**From:** Jack Spees <jack@ribbletrust.com>  
**Sent:** 06 September 2018 16:00  
**To:** planning  
**Subject:** Objection to Application 3/2018/0750

We are writing to object to the planning Application 3/2018/0750.

Title **Proposed Site Layout & Curtilage Area** DFK N° **415/2/3**
Rev. **A**

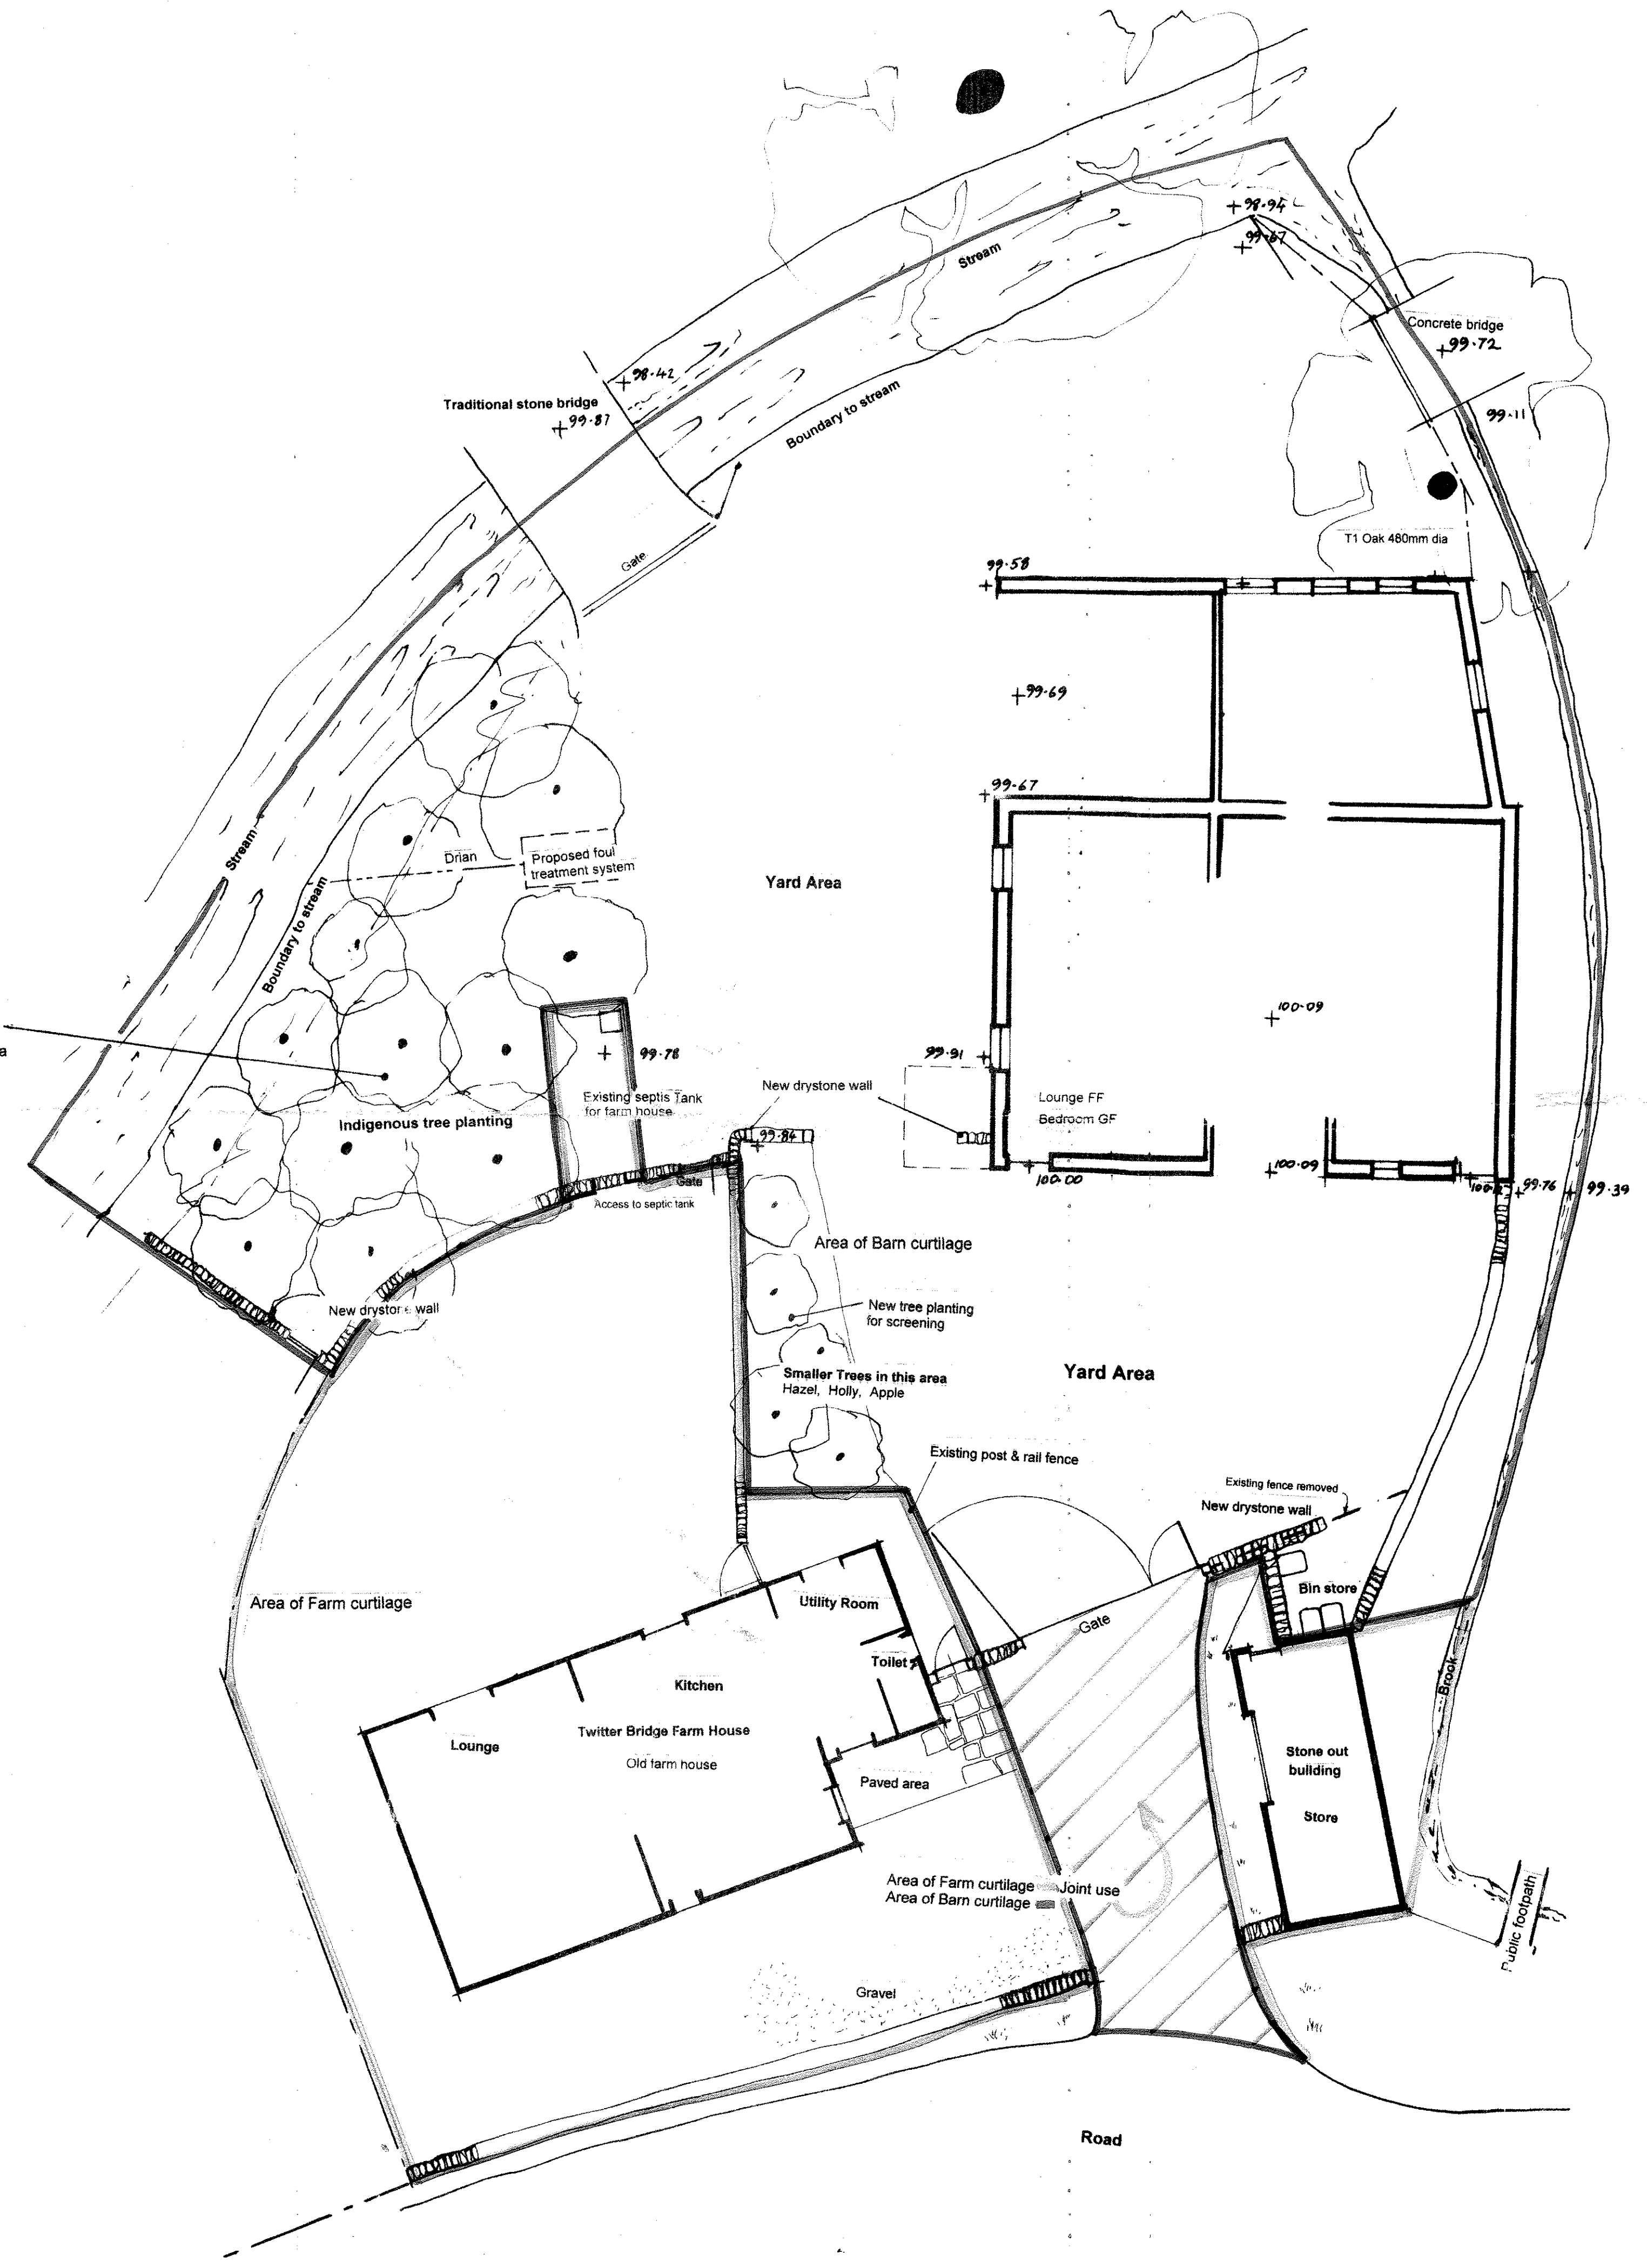
- The proposed foul treatment system falls in the flood zone, and there is no detail around its specification or functionality. Its location has the potential to cause pollution from alluvial flooding, and the specification is required to determine what the ecological impact would be to brook, we feel that it would be more appropriate that foul water be discharged to the sewer if possible, even if at greater cost.
